Our Ref: 19-142**Mr David Gibson (Team Leader)**

RE: S4.55(1A) MODIFICATION APPLICATION TO SSD 14_6848 IN RELATION TO THE STAGE 3B DEVELOPMENT AT LISMORE BASE HOSPITAL

The subject application specifically relates to the approved Stage 3B2 North Tower.

1 GA - Level 03 3B2
A30001 1 : 200

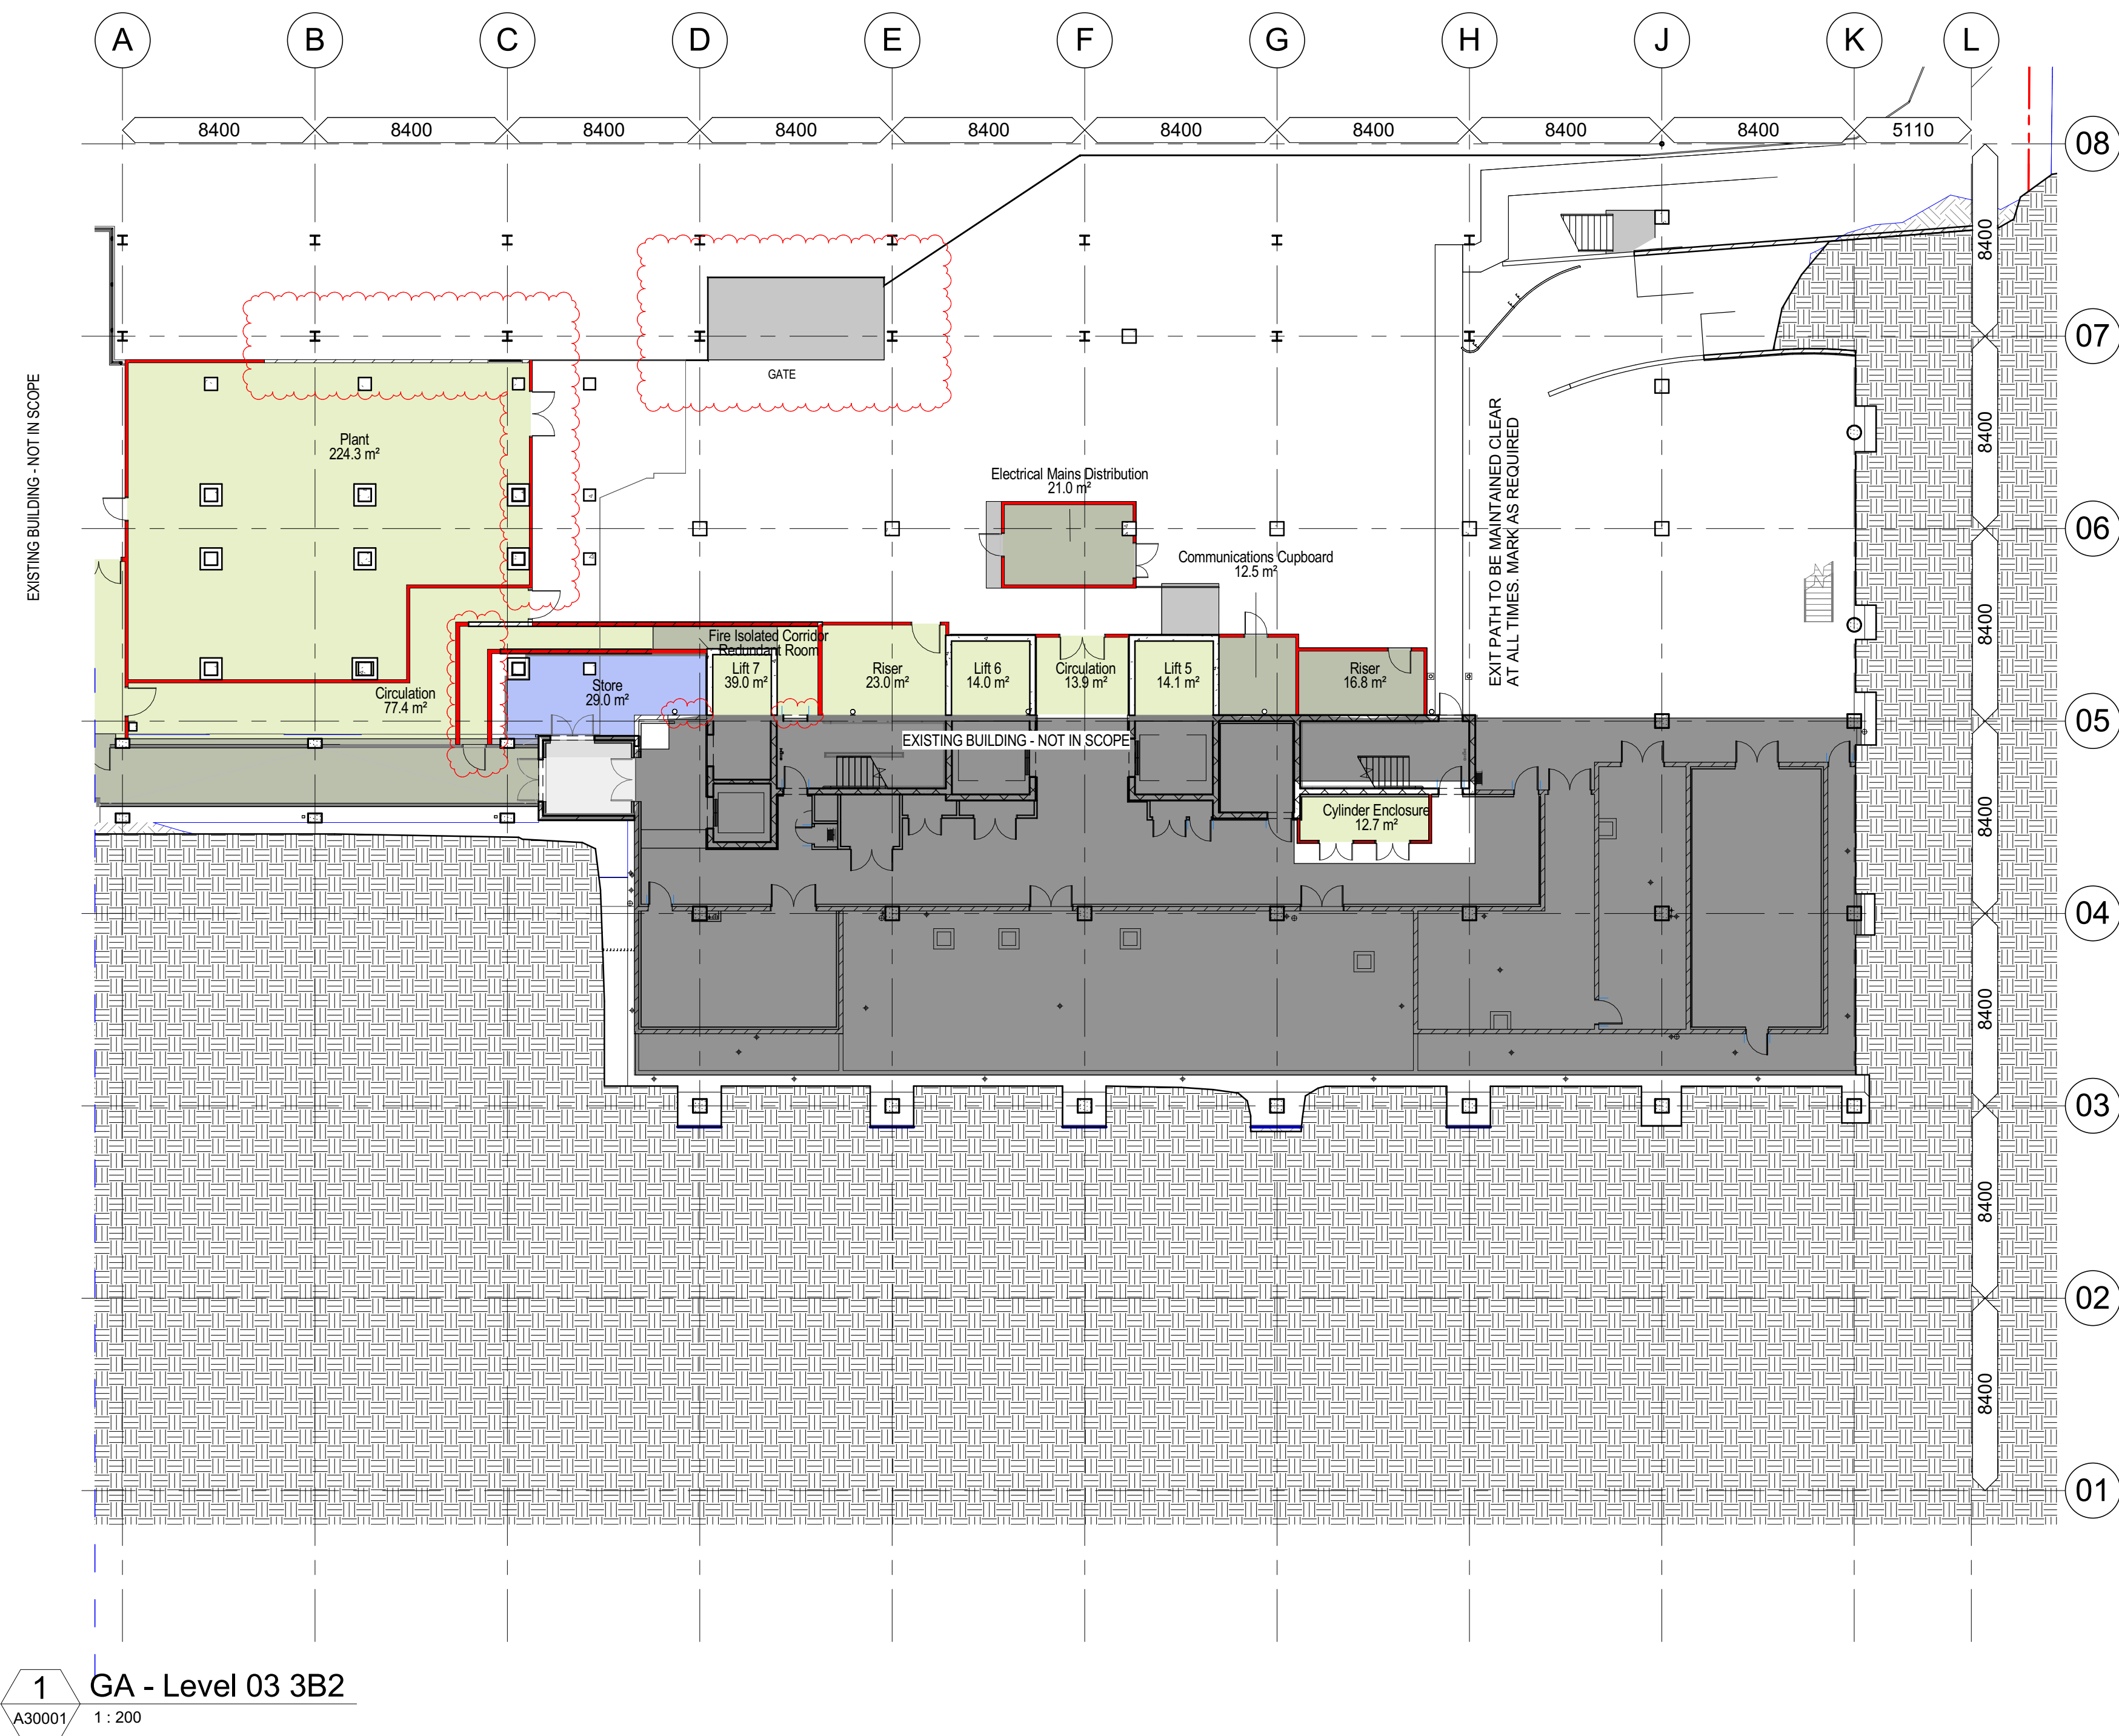
- Level 3: Reduction in the extent of plant, removal of the chiller enclosure (noting this area will become an extension to the general level 3 undercroft hardstand area), realignment of a fire passage, minor modification to the extent louvres in nominated locations, the fire passage door has been removed at 'stair 1' (to satisfy fire engineering requirements) and relocation of the door to the main plant space further north to better align with final plant layouts. Refer to the following comparative Level 3 floor plans for a visual representation of the proposed changes.

Schedule of Changes - North Elevation 3B2	
Item	Comments
1	Quench pipe design adjusted, level 5 grid H
2	Security gate level 4 grid H
3	Block wall alignment adjusted west grid C
4	Mechanical duct shown grid B
5	Extent of louvres adjusted grid C

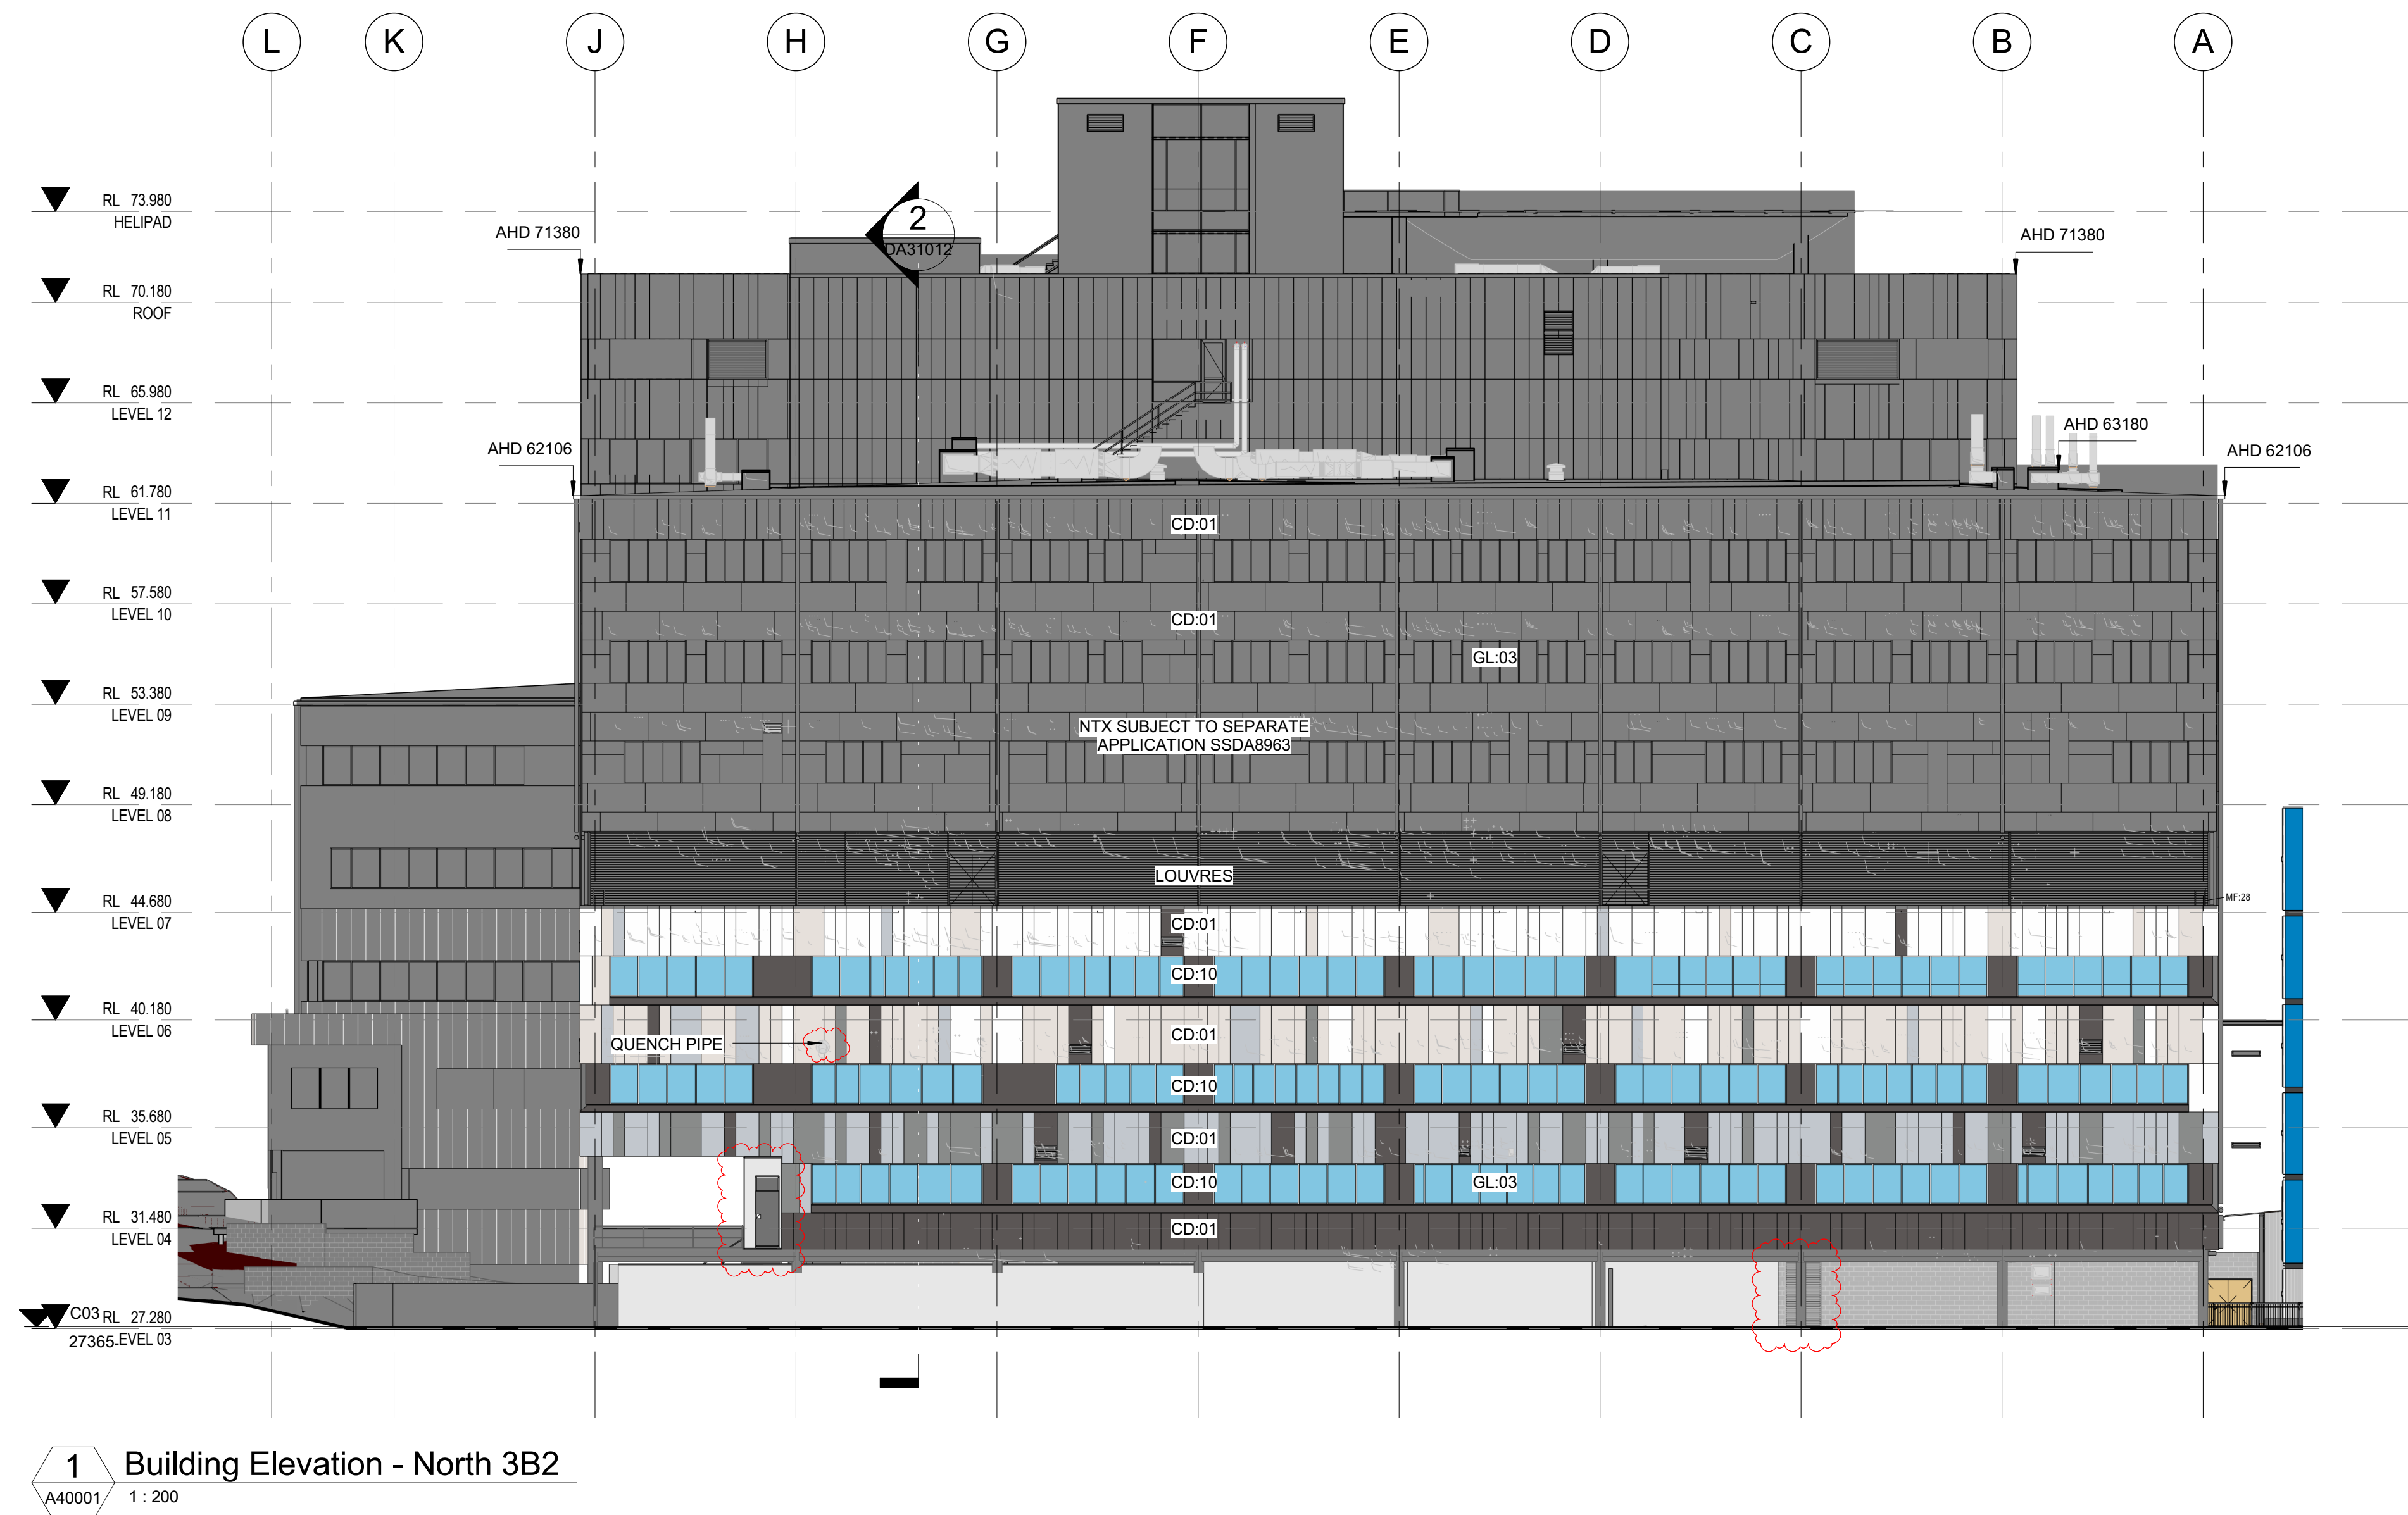
- Northern Façade: adjustment of the approved quench pipe location and design at Level 5, inclusion of a security gate at Level 4, minor adjustments to the wall alignment and extent of louvres within "grid C" at Level 3 (refer to attached plans for grid locations) and inclusion of mechanical relief air duct at "grid B" at Level 3;
